**State Significant Development (SSD – 8184) – Fairfield Sustainable Resource Centre
Expansion – Public Authority Consultation (PAE – 9063802)**

CD20/07169

SEDIMENT AND EROSION  
CONTROL PLAN - SHEET 2 OF 3

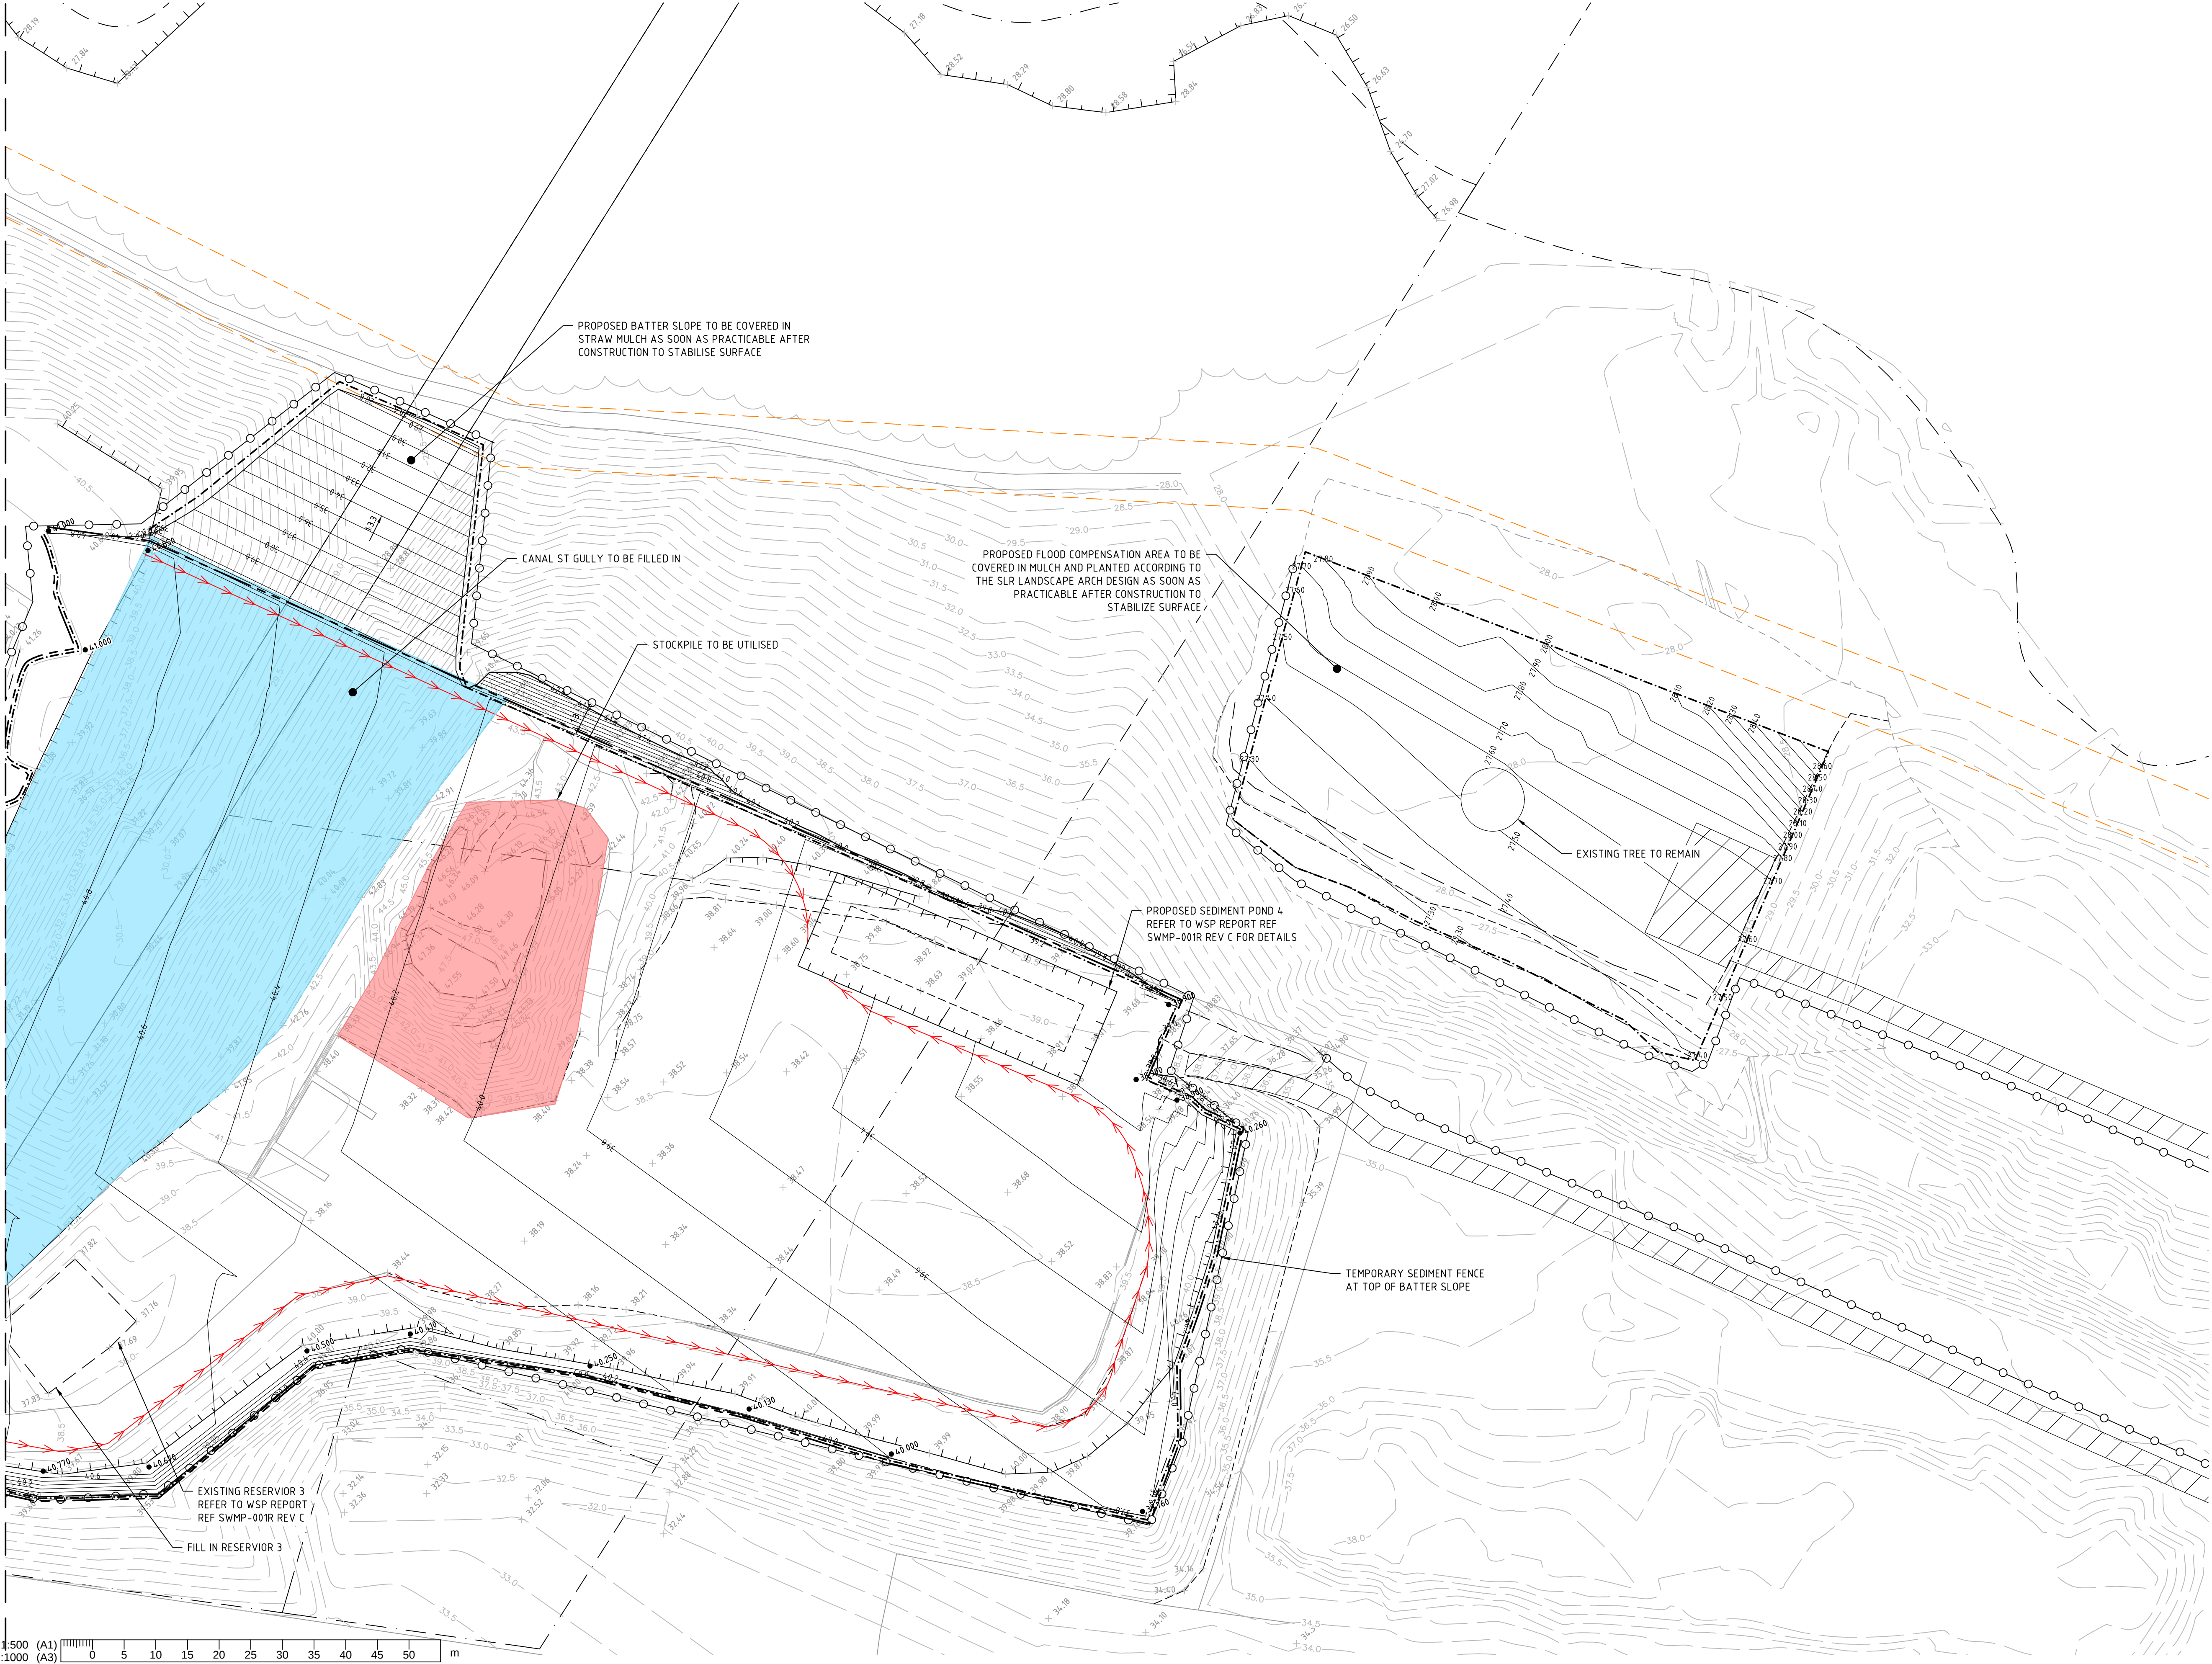
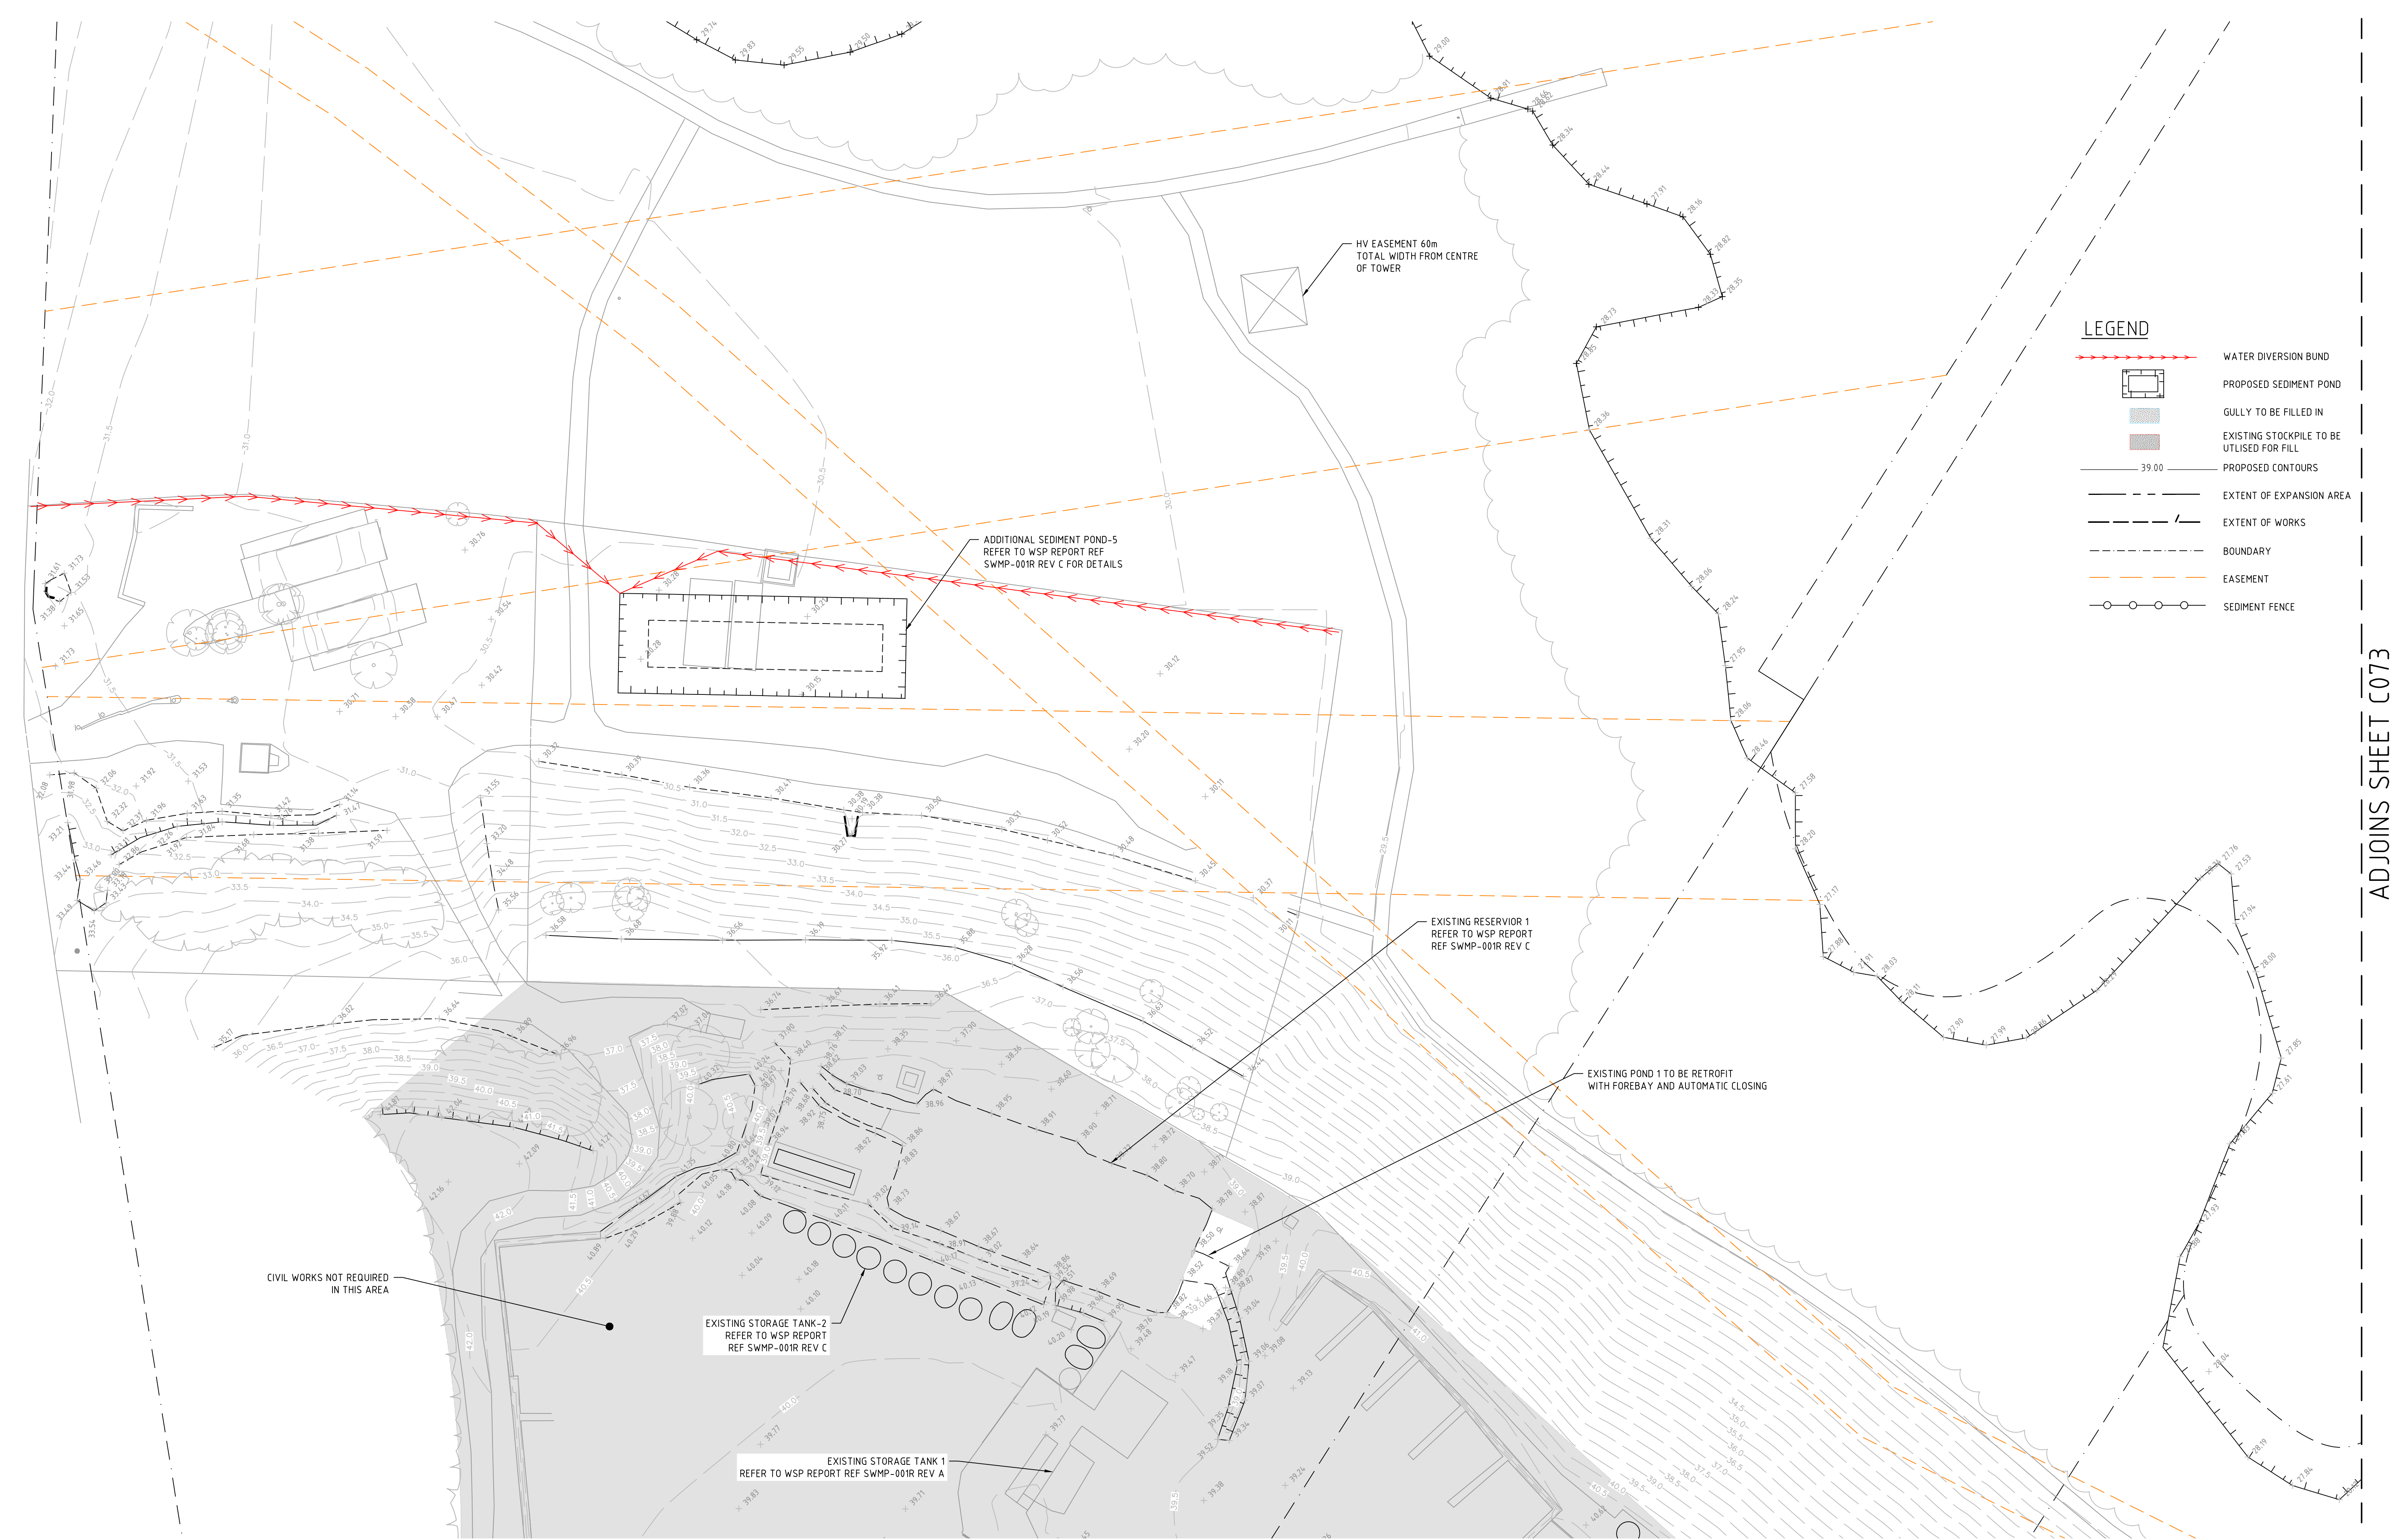
At this stage the rail is designed on structure through the subject site, minimising potential impacts. That notwithstanding, the size and location of the proposed sediment basins may impact the future constructability of the rail infrastructure.

To minimise the impact of the proposal on the deliverability of the future infrastructure, it is recommended that the applicant be conditioned to consult with TfNSW to determine the location and design of the sediment basins.
